Appeal Decision

Appeal Ref: APP/Z4718/D/19/3227847

7 Lake View, Armitage Bridge, Huddersfield, HD4 7NX

- The appeal is made under section 78 of the Town and Country Planning Act 1990 against a refusal to grant planning permission.
 - The appeal is made by Gloria Gough against the decision of Kirklees Metropolitan Council.
 - The application Ref 2019/62/90351/W, dated 6 February 2019, was refused by notice dated 5 April 2019.
 - The development proposed is the erection of a conservatory.
-

Client: Gloria Gough	Project: Conservatory	Scale: 1:100	Date: January 2018
Address: 7 Lake View	Dwg Title: Conservatory Plans	Dwg No: LV03	Status: Planning
Armitage Bridge, HD4 7NX		Revision: #

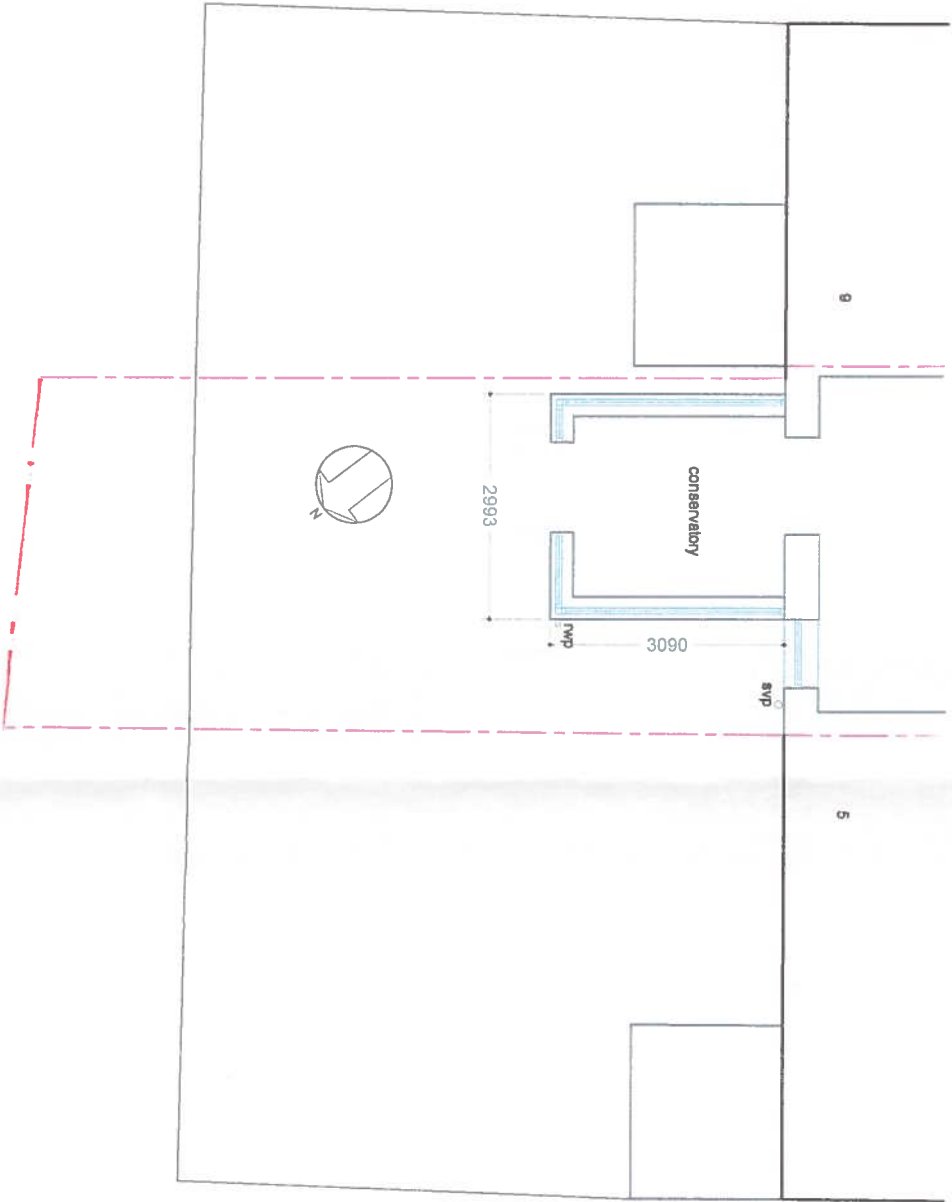
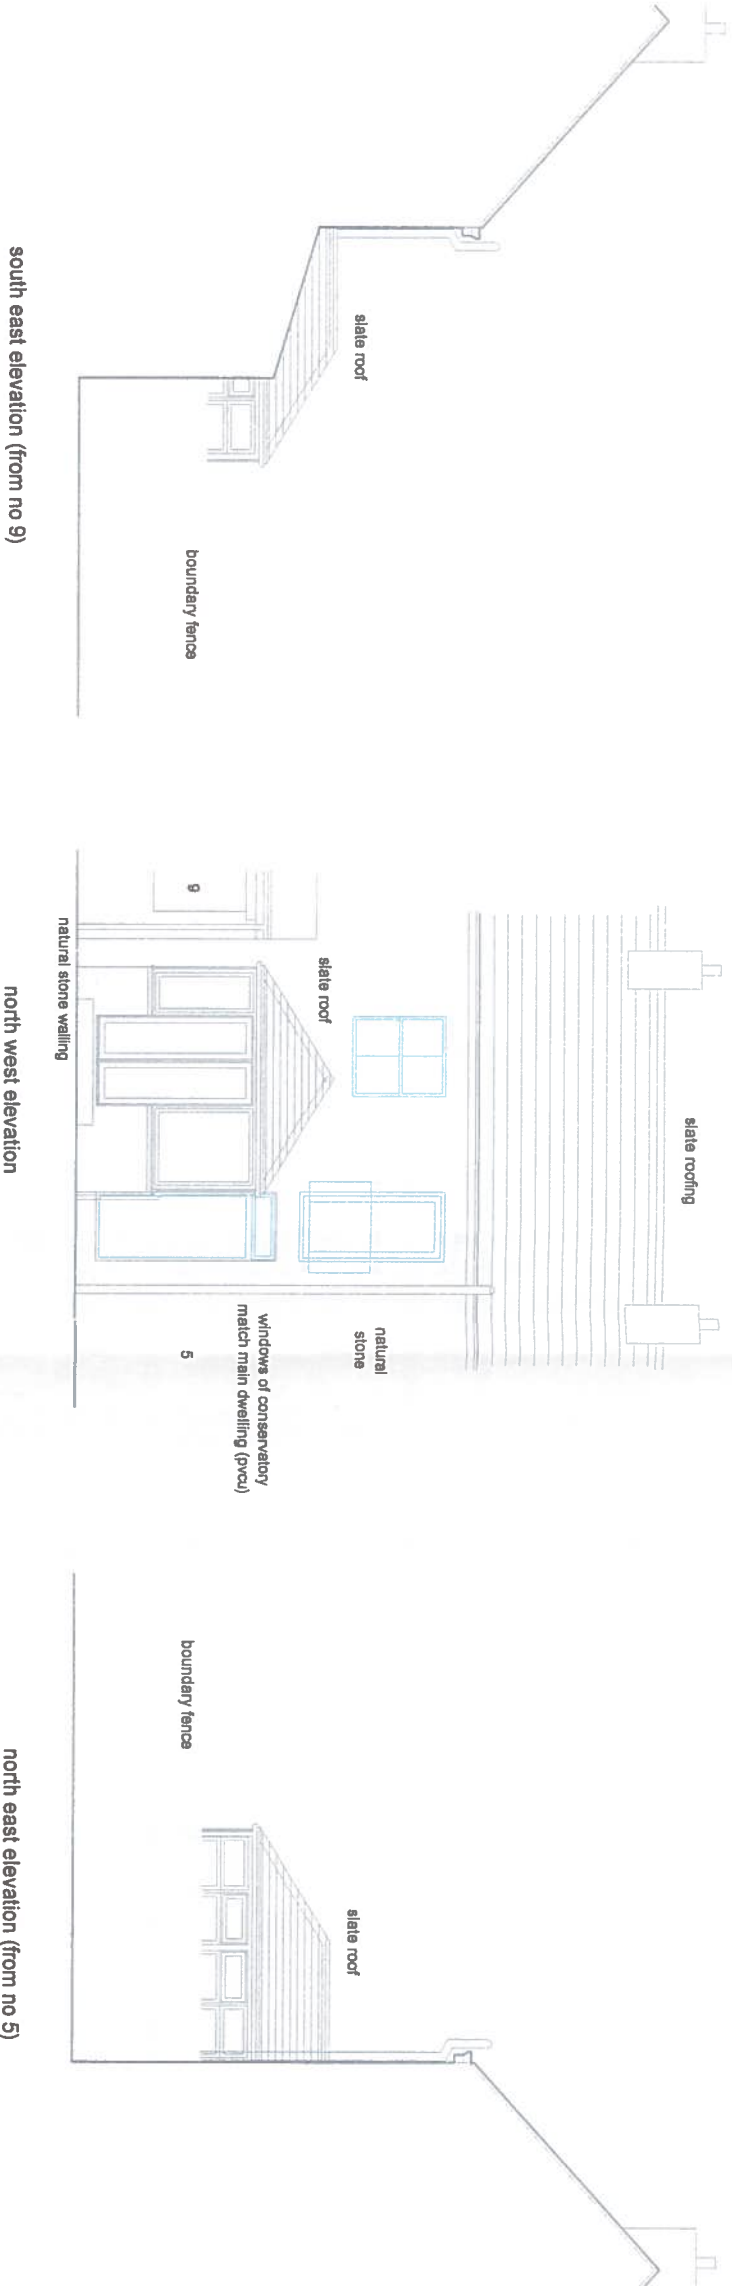
6. The conservatory projects around 3m from the main two storey wall of the dwelling and has a similar width to its projection. It is separated from the neighbour at No. 5 by a distance of around 1.5m, but does extend across most of the width of the dwelling. At the time of my site visit, I was able to see that the terrace along the north-eastern frontage retained its original form, with projections forward of the main two storey facade limited mainly to some porch structures around entrance doors. In contrast to this, the scale of the appeal proposal, despite its construction in wall materials that are sympathetic to the existing property, as well as having gutters in a traditional style, has resulted in a large addition to the dwelling. The extension detracts from the generally uniform and consistent character of the terrace row and has intruded into a largely open garden area.

7. The roof materials, although formed of slate, are different to the stone slate materials of the main dwelling. This along with the shallow hipped roof form, which also differs from the simple pitched roof form of properties in the area, draws attention to the development, resulting in it appearing conspicuous in its surroundings.

8. I conclude therefore that the appeal development has an unacceptable adverse effect on the character and appearance of the host dwelling and the area and also fails to preserve or enhance the character and appearance of the Conservation Area. It is contrary to Policies LP 24 and LP 35 of the Kirklees Local Plan, which seek, amongst other matters, good design that enhances the character of the townscape and development that preserves or enhances the significance of the heritage asset. It would also be contrary to paragraph 193 of the National Planning Policy Framework (Framework), which states that great weight should be given to a heritage asset's conservation. In relation to paragraph 196 of the Framework, this states that where there would be harm that is less than substantial, as in this case, it must be weighed against the public benefits of the proposals.
